July 7<sup>th</sup>, 2014

Project Name: **Auto Dealership selling pre-owned cars**  
Project ID: #2014-025 & #2013-044 CBL: 130-C-001  
Address: 783 Forest Avenue  
Applicant: Changiz Fard  
Planner: Jean Fraser

On June 24<sup>th</sup>, 2014, the Planning Board considered the proposed change of use and site alterations for an Auto Dealership selling pre-owned cars at 783 Forest Avenue. The Planning Board reviewed the proposals for conformance with the standards of the Conditional Use and Site Plan Ordinances.

# Proposal

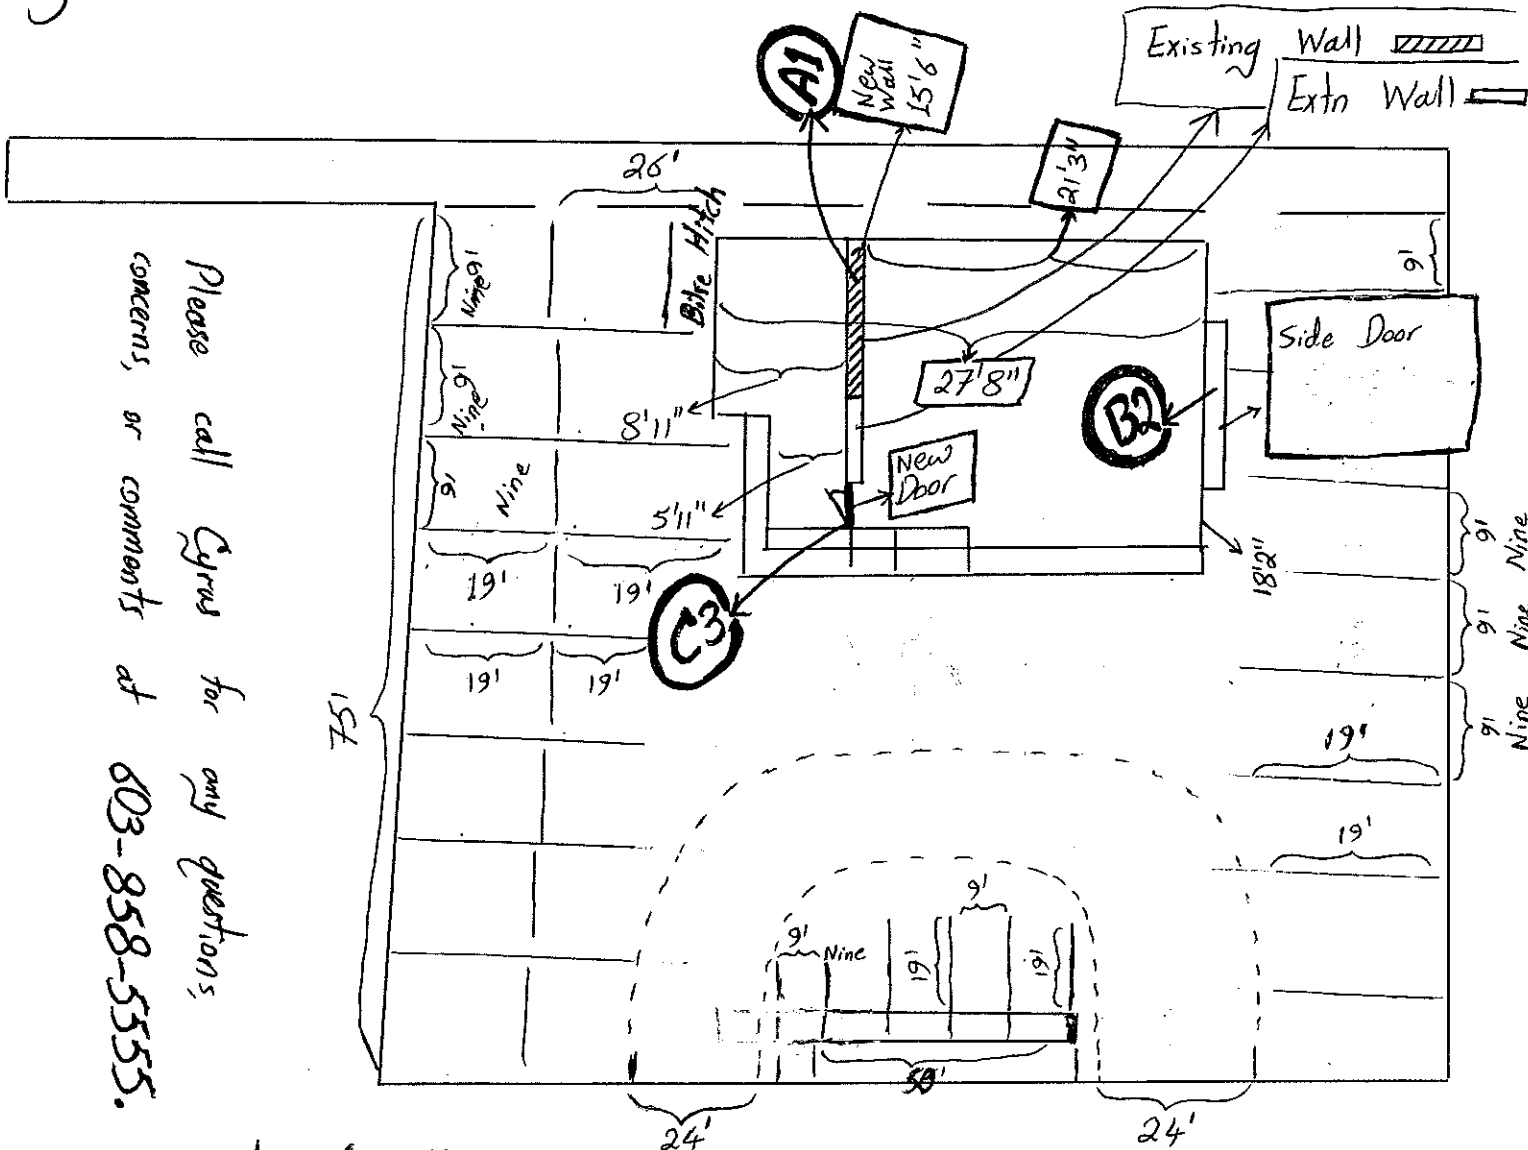
- iii. That the “Improvements Plan” (Plan P2 in this report) shall be revised for review and approval by the Planning Authority prior to implementation, to: 1) expand the planted buffer along Forest Avenue to be approximately twice the length shown on the plan; 2) show that the existing trees along the rear of the site are to be preserved; and 3) show that the existing lights on the building shall be modified to be “cut-off” in type and on a timer that lowers the light levels at night (one hour after the business closing to one hour before business opening, per City Technical Standards 12.2.8) ; and

- ii. That a revised final site plan (“Improvements Plan”) shall be submitted for review and approval prior to implementation, to: 1) expand the planted buffer along Forest Avenue to be approximately twice the length shown on the plan; 2) show that the existing trees along the rear of the site are to be preserved; and 3) show that the existing lights on the building shall be modified to be “cut-off” in type and on a timer that lowers the light levels at night; and
